13 August 2018

**Section 4.55(1A) Modification to Amend SSD 6848 Lismore Base Hospital
Stage 3B Development**

On 1 May 2015, Stage 3B of the Lismore Base Hospital redevelopment was approved. SSD 6848 has been modified on three (3) occasions (Mod 1, 2 and 3) with a fourth modification application lodged but withdrawn.

1 Building Elevation - East 3B2
1 : 200

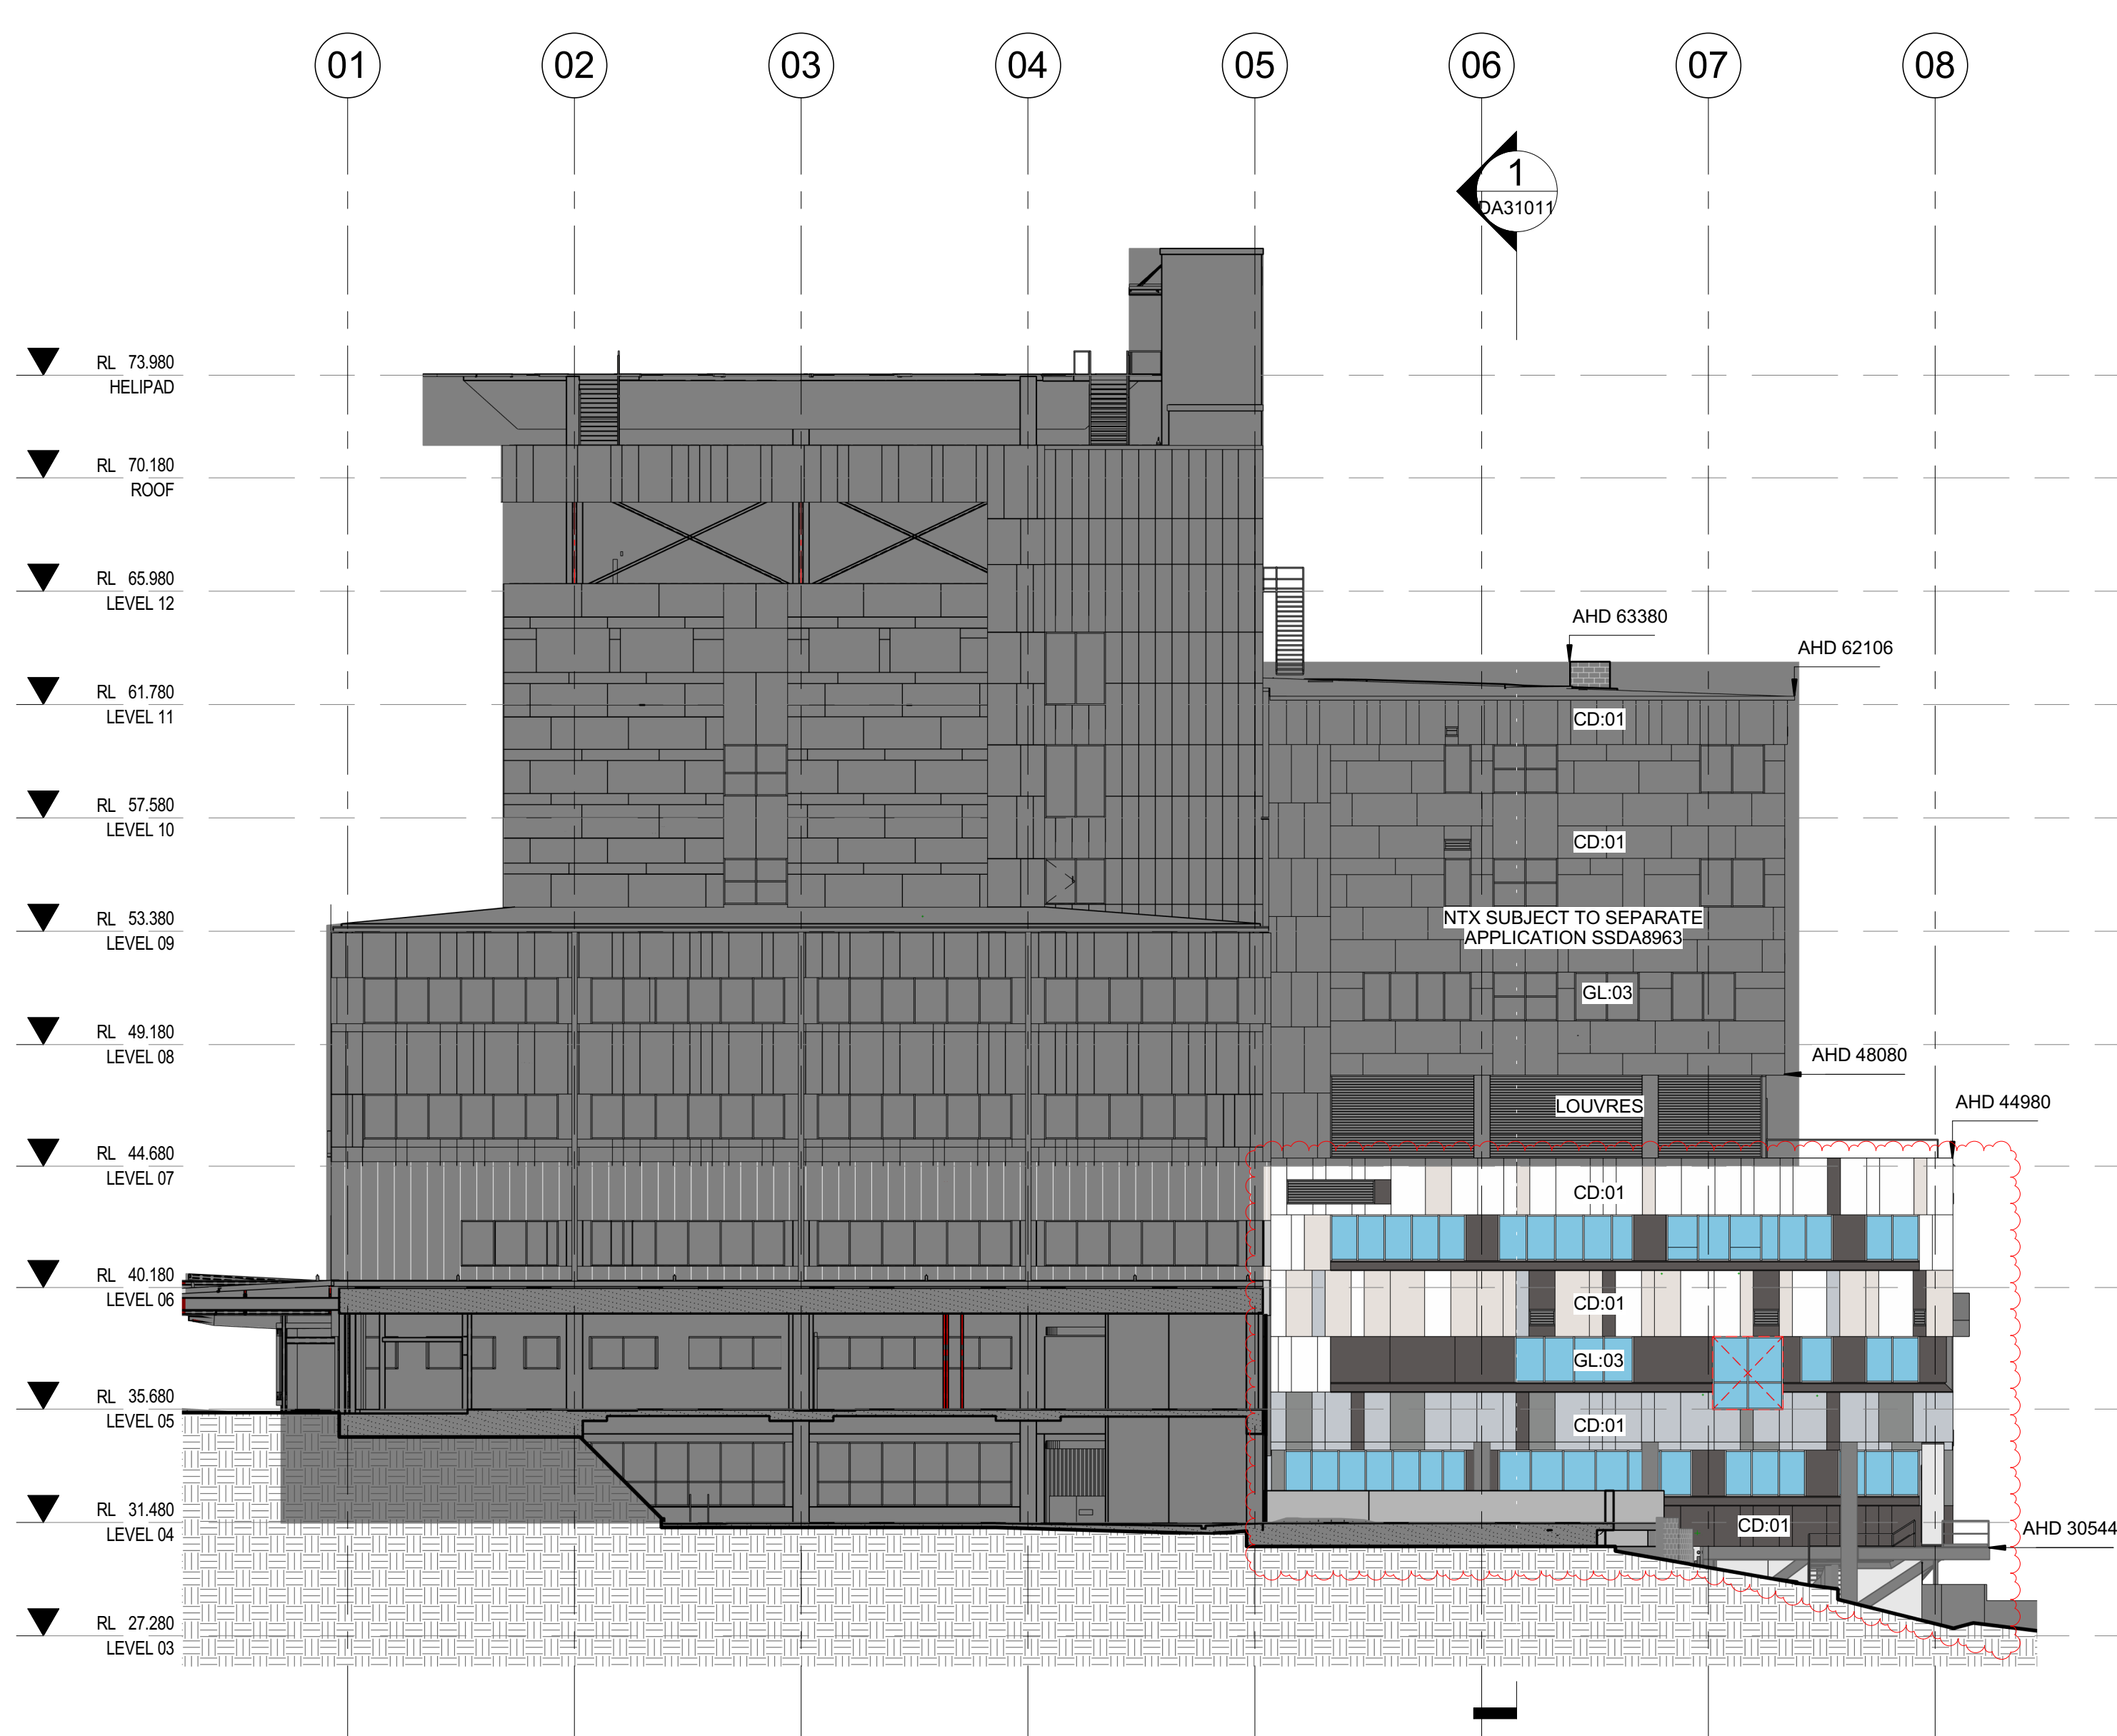
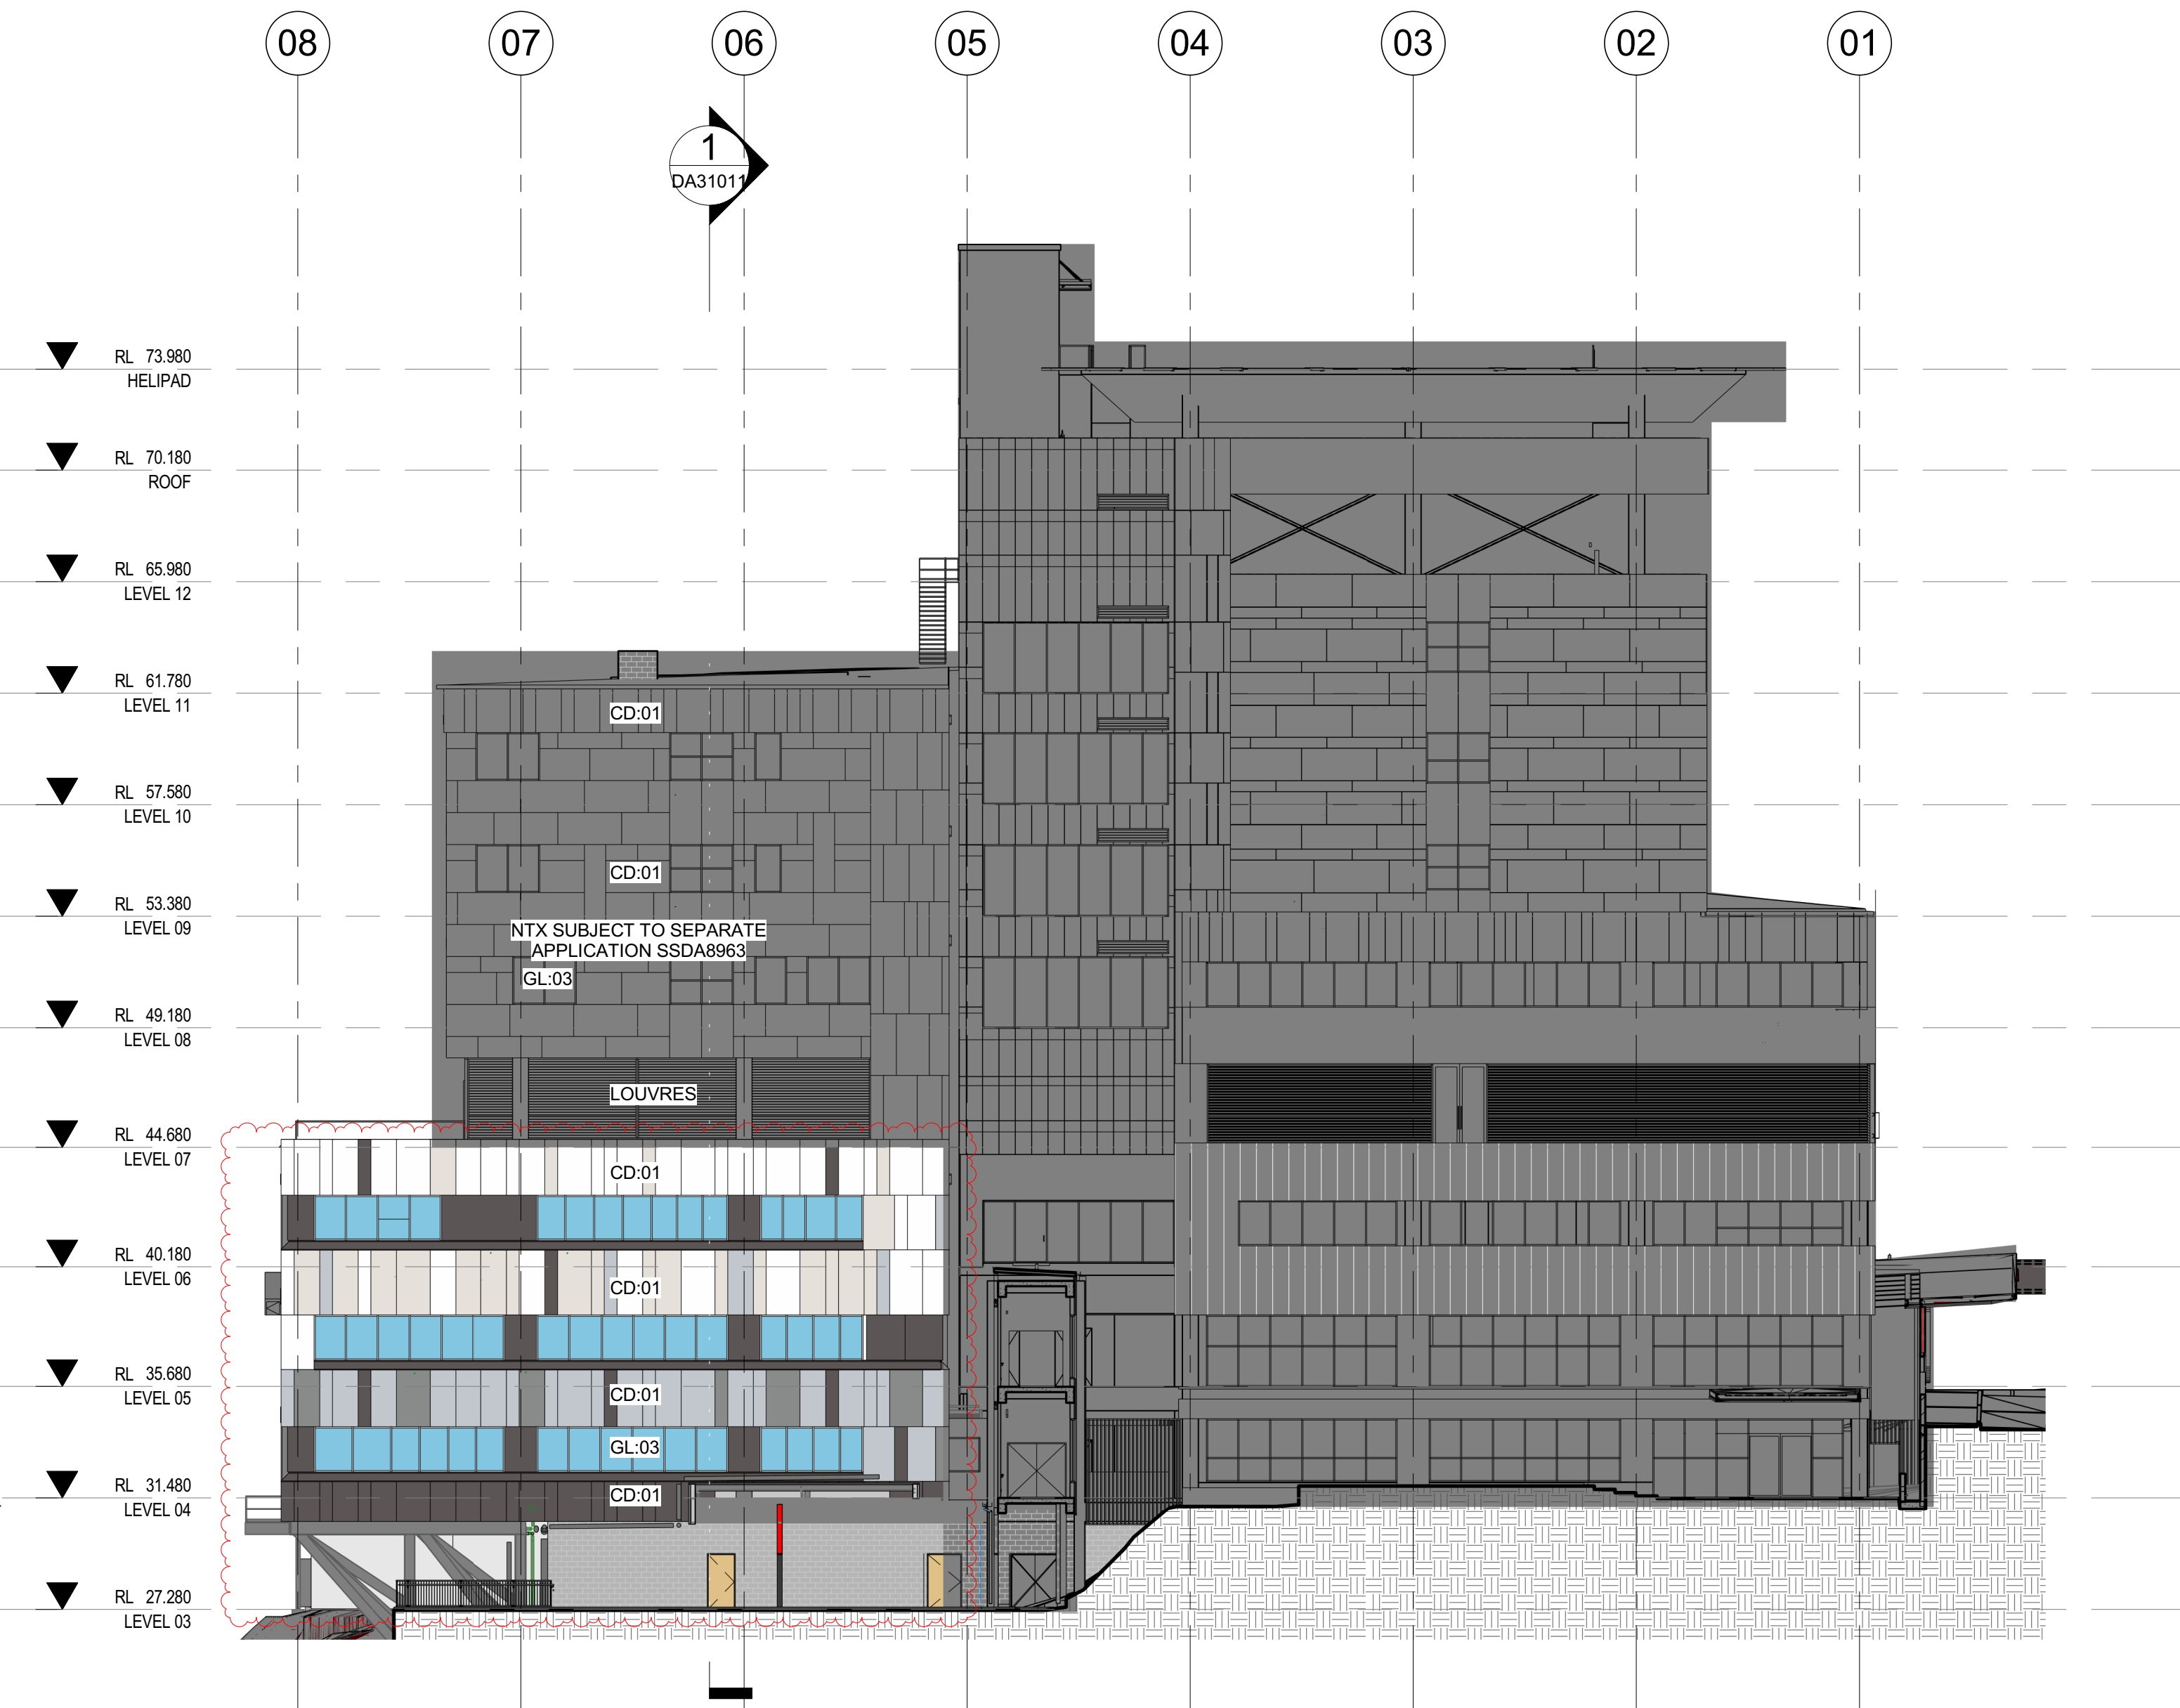
- Amendments to the external façade design and colour scheme of the Stage 3B2 North Tower, as follows:
- Amendment of design language and window placement to the façade (to suit internal layout);
- Change of the façade colour palette to muted/varied greys. Whilst the colour scheme is proposed to be amended, the materials and finishes will remain unchanged;
- Incorporation of quench pipe box and large removable window for MRI; and
- Extent of louvre panelling reduced at Level 03 as a result of the proposed reduction in plant space.

1 GA - Level 06 3B2
A30001 1 : 200

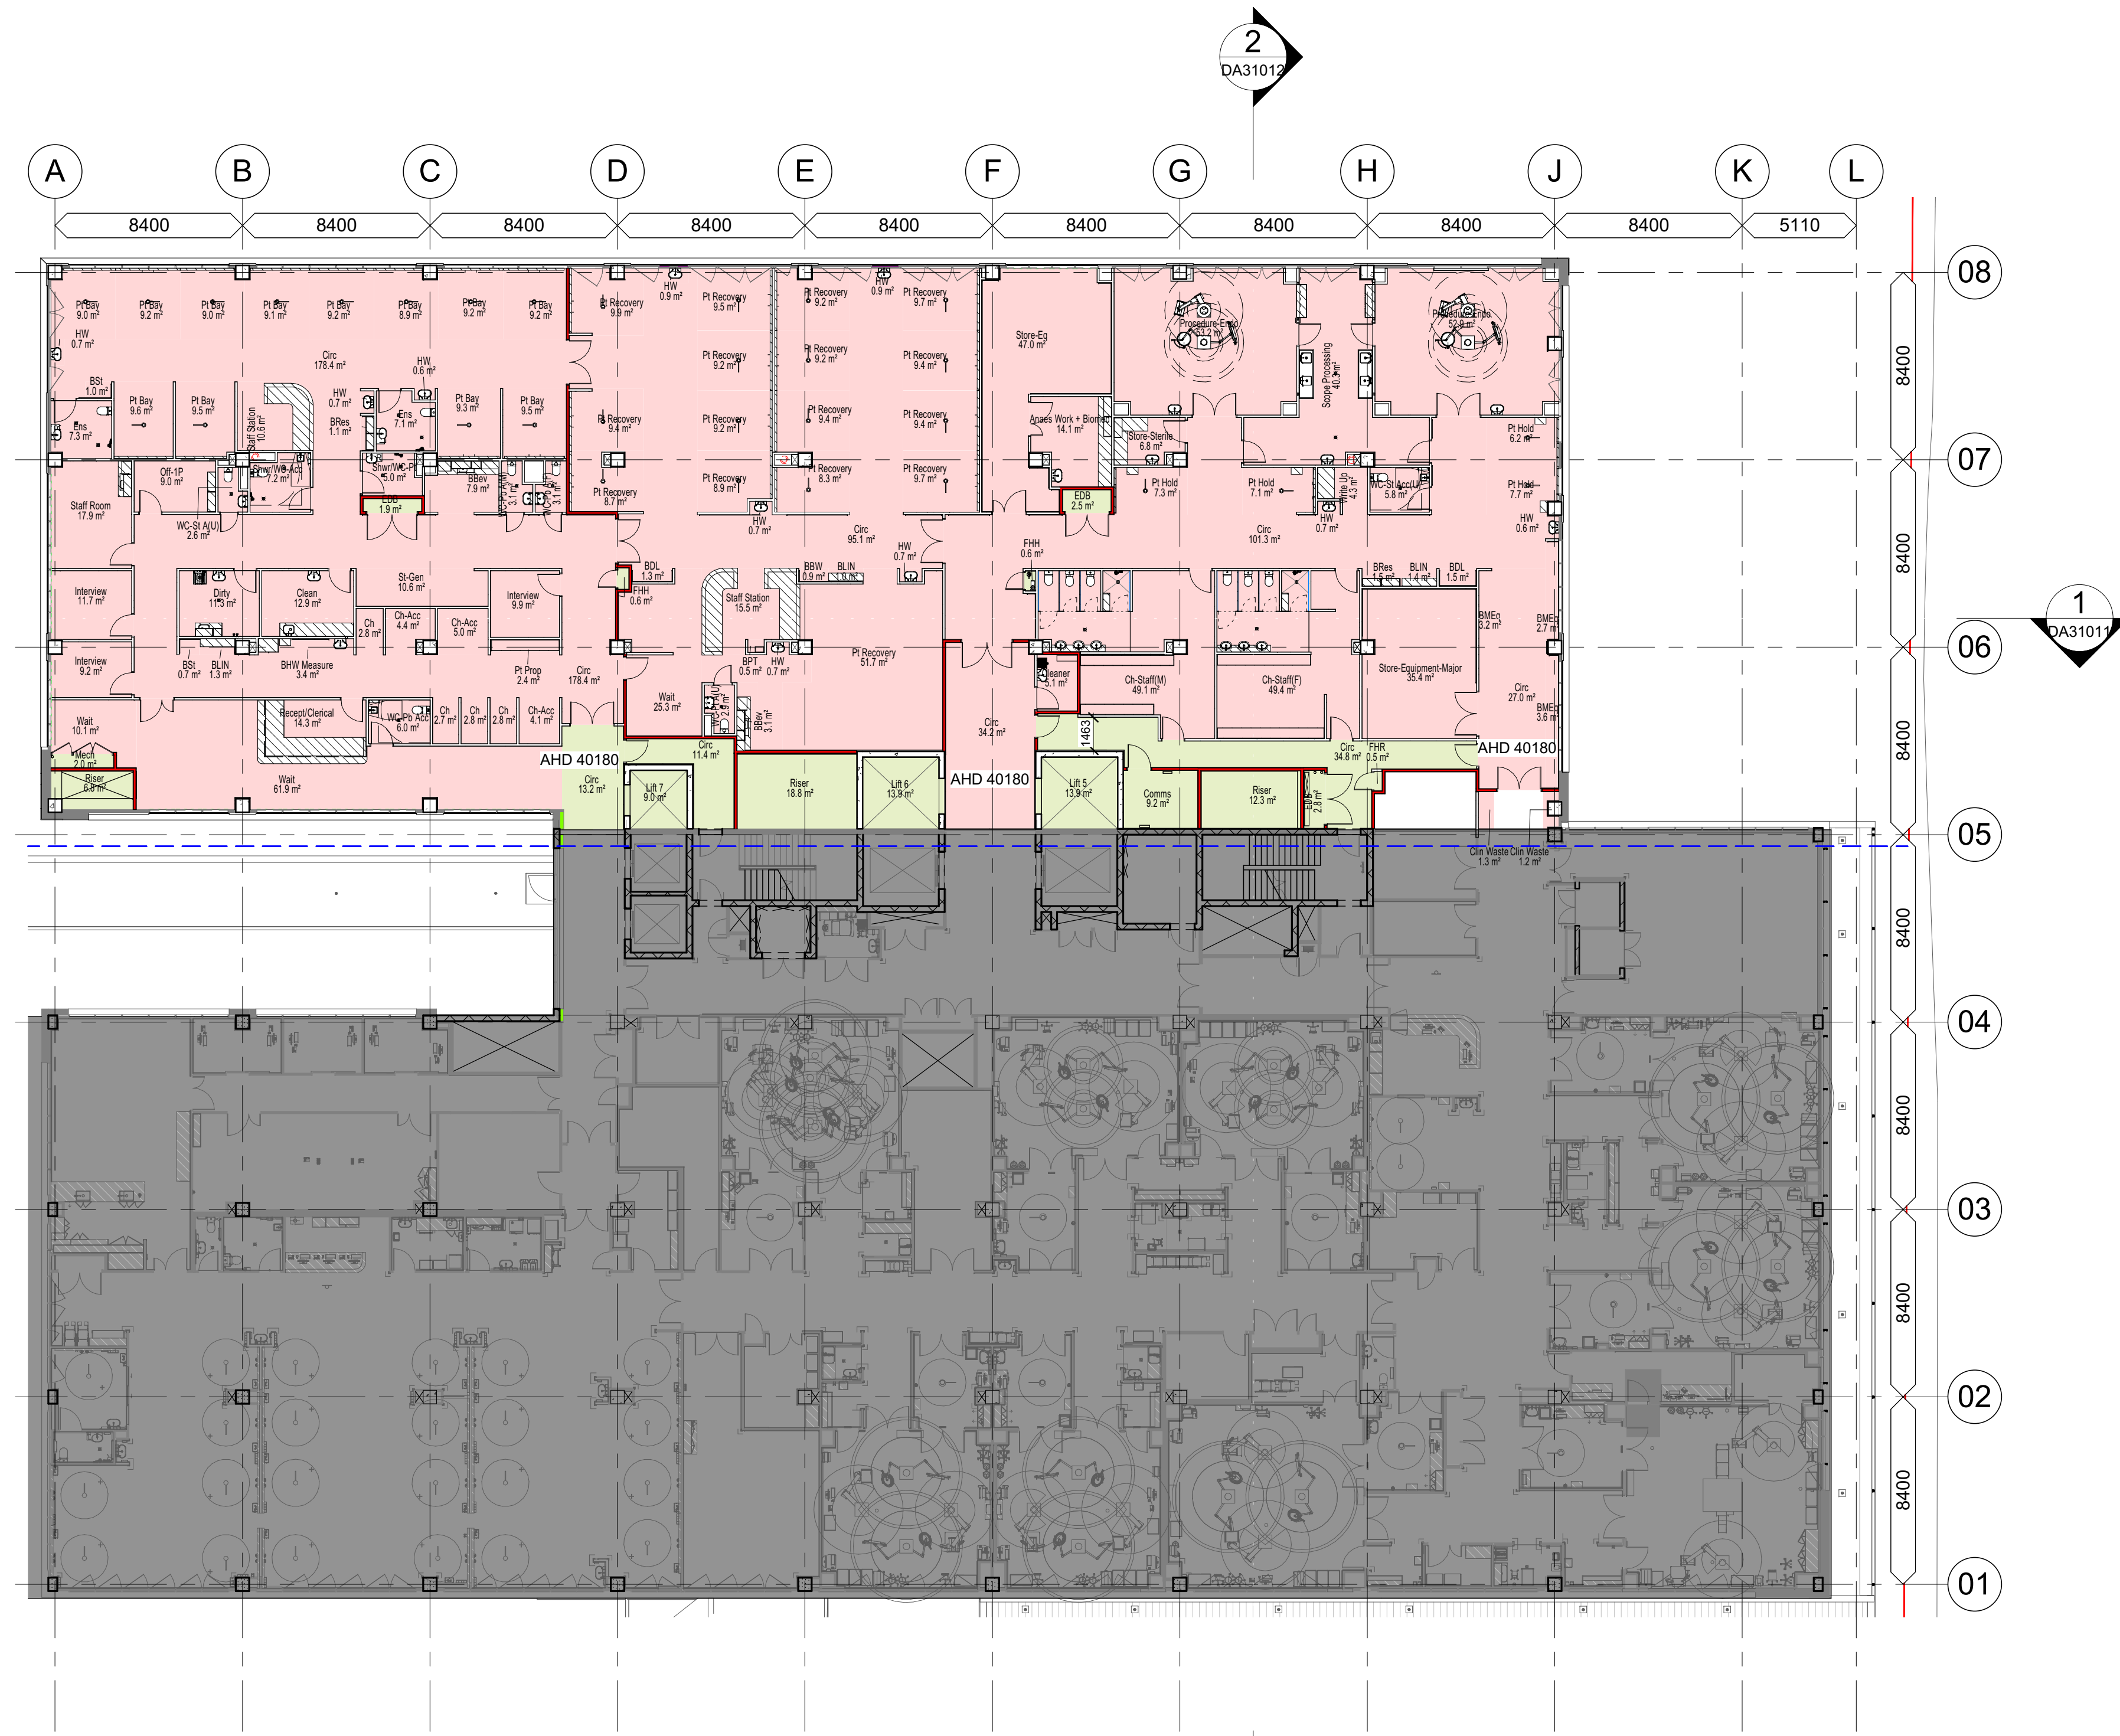
- Minor modifications to the internal layout of Levels 04, 05 and 06, including:
 - Rationalisation of fire compartmentation and overall strategy;
 - Inclusion of an additional public lift within an approved void/shell space (known as “lift 7”);

- Removal of the approved link bridge to Level 06, connecting the two (2) towers;
